## EL PASO COUNTY GRADING AND EROSION CONTROL PLAN CHECKLIST

← SF2237

STERLING RANCH EAST FILING NO. 2
 CONSTRUCTION PLANS
 INITIAL GRADING AND EROSION CONTROL PLAN

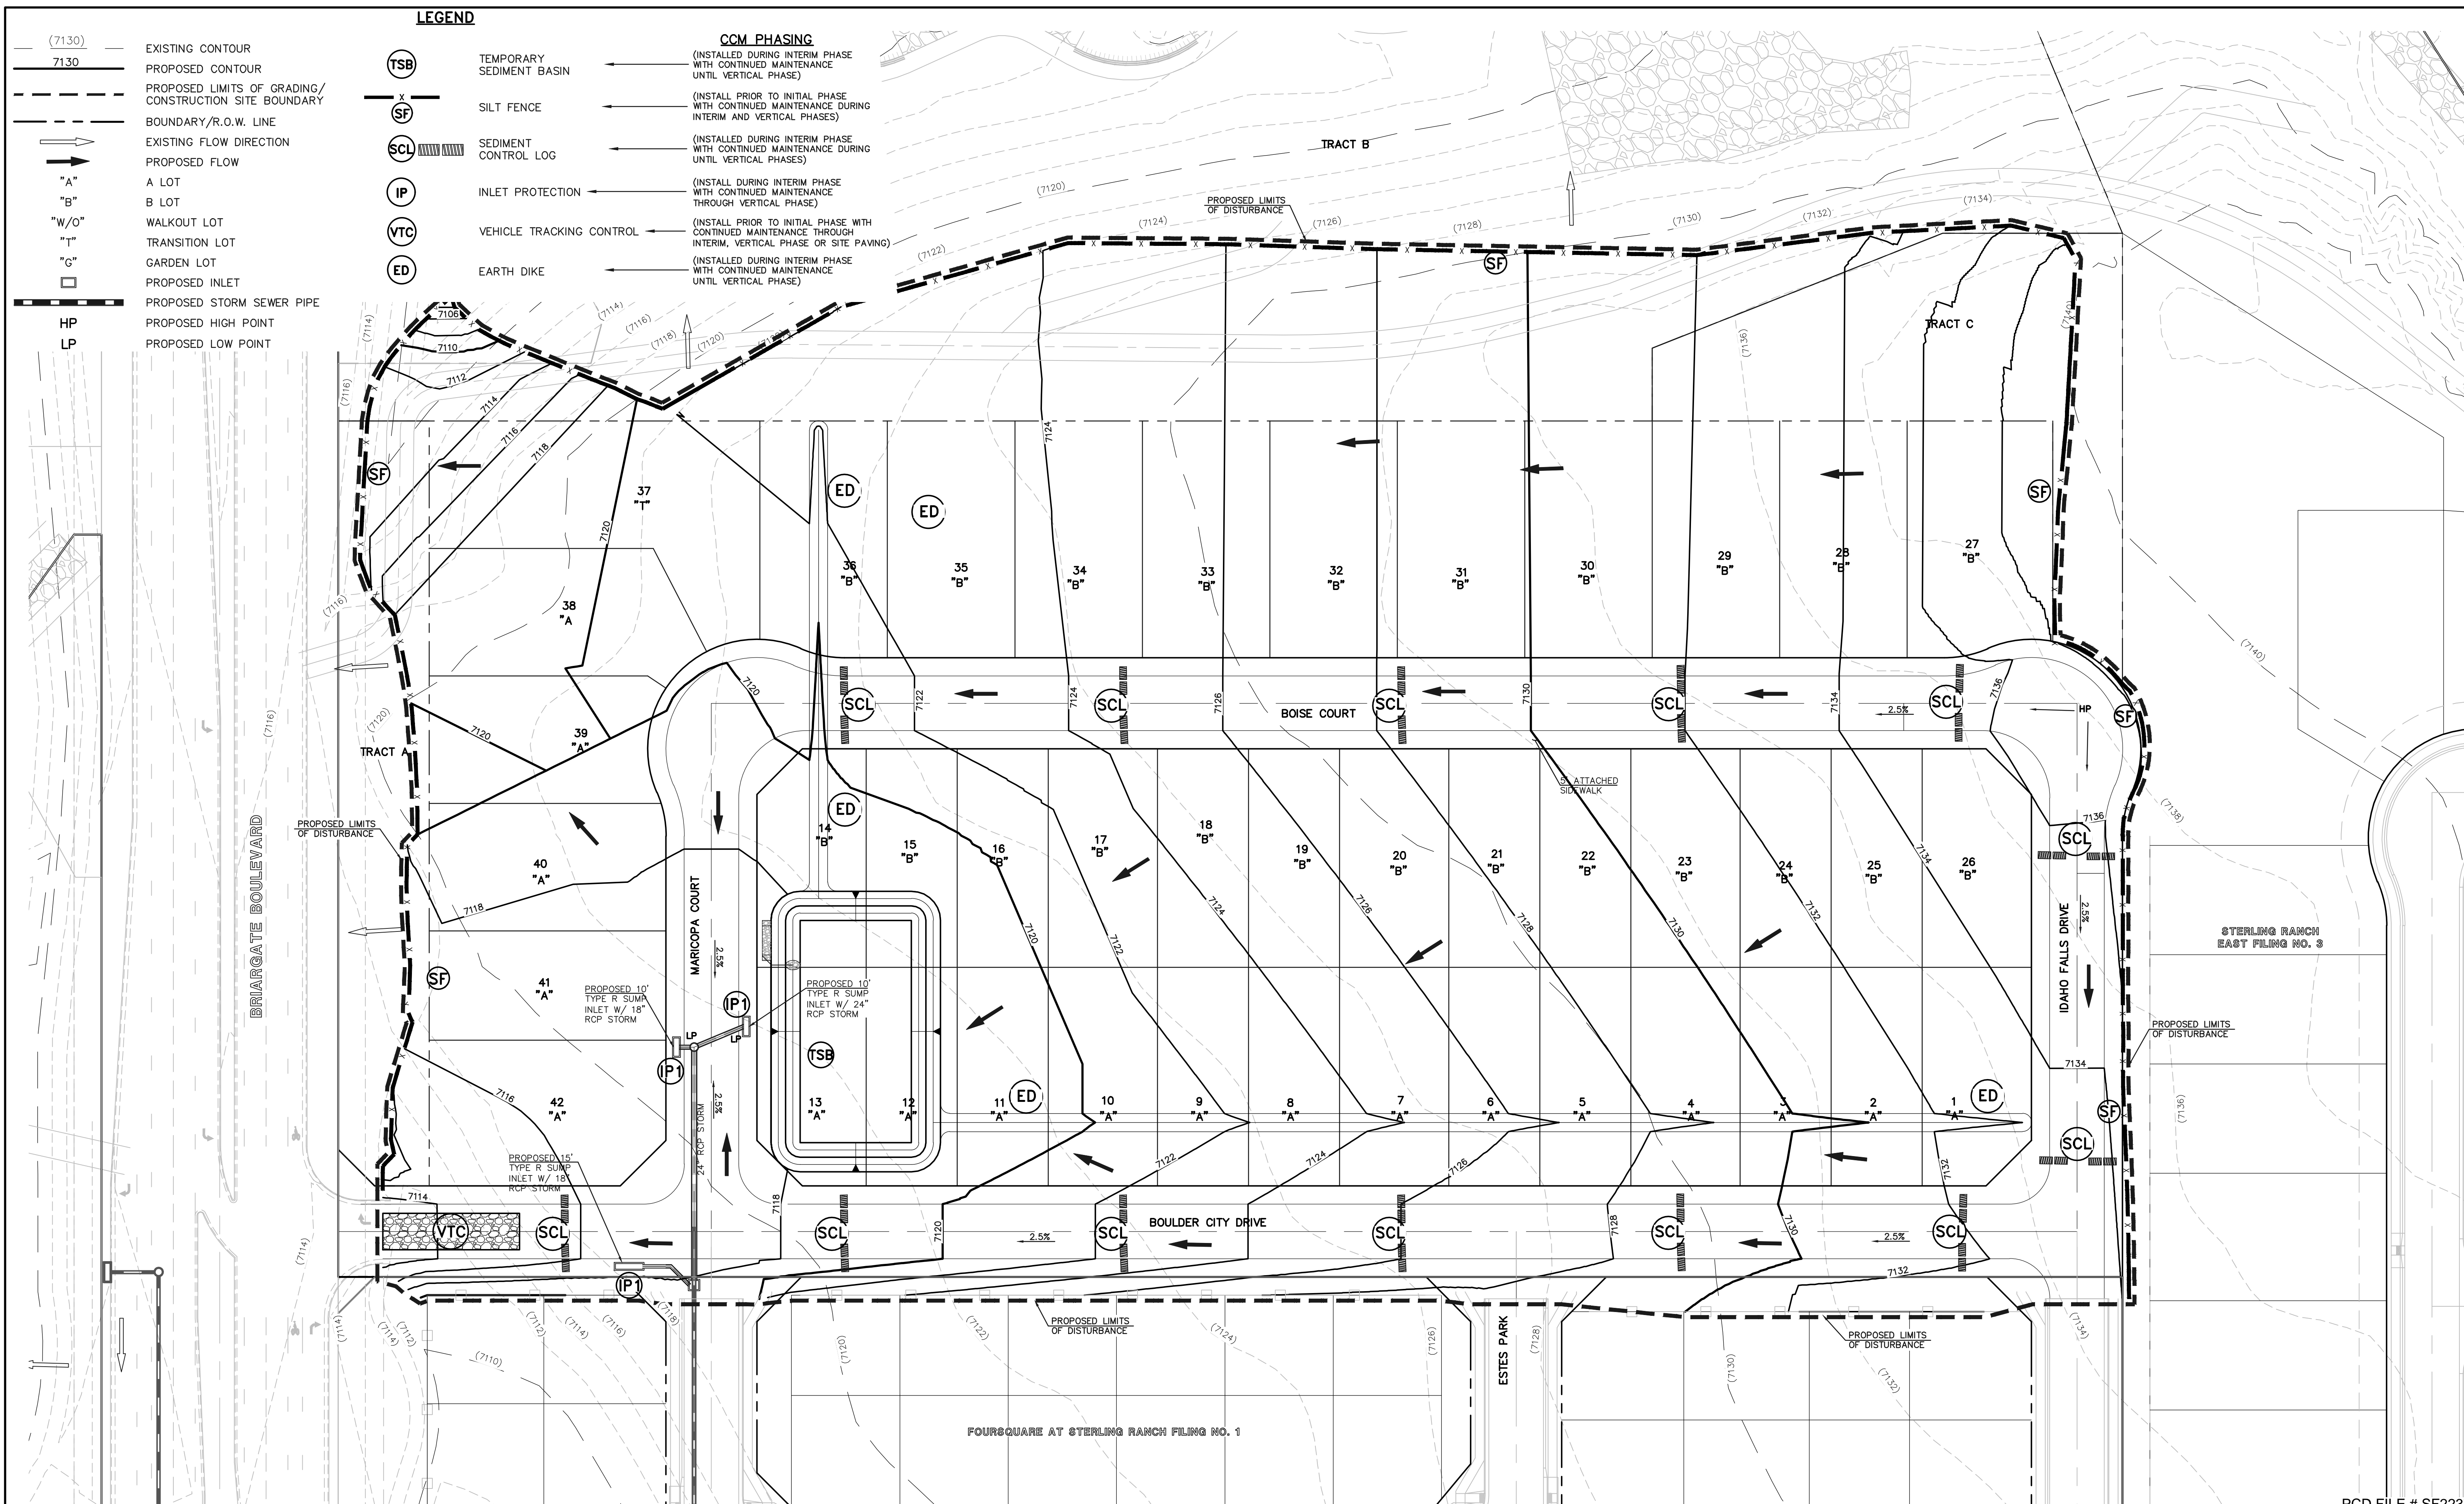
v	All proposed temporary construction control measures, structural and non-structural. Temporary construction control measures shall be identified by phase of implementation to include "initial," "interim," and "final" or shown on separate phased maps identifying each phase		Y
w	Vehicle tracking provided at all construction entrances/exits. Construction fencing, barricades, and/or signage provided at access points not to be used for construction		Y
x	Temporary sediment ponds provided for disturbed drainage areas greater than 1 acre		N

See my comment on Sht 2 of CDs
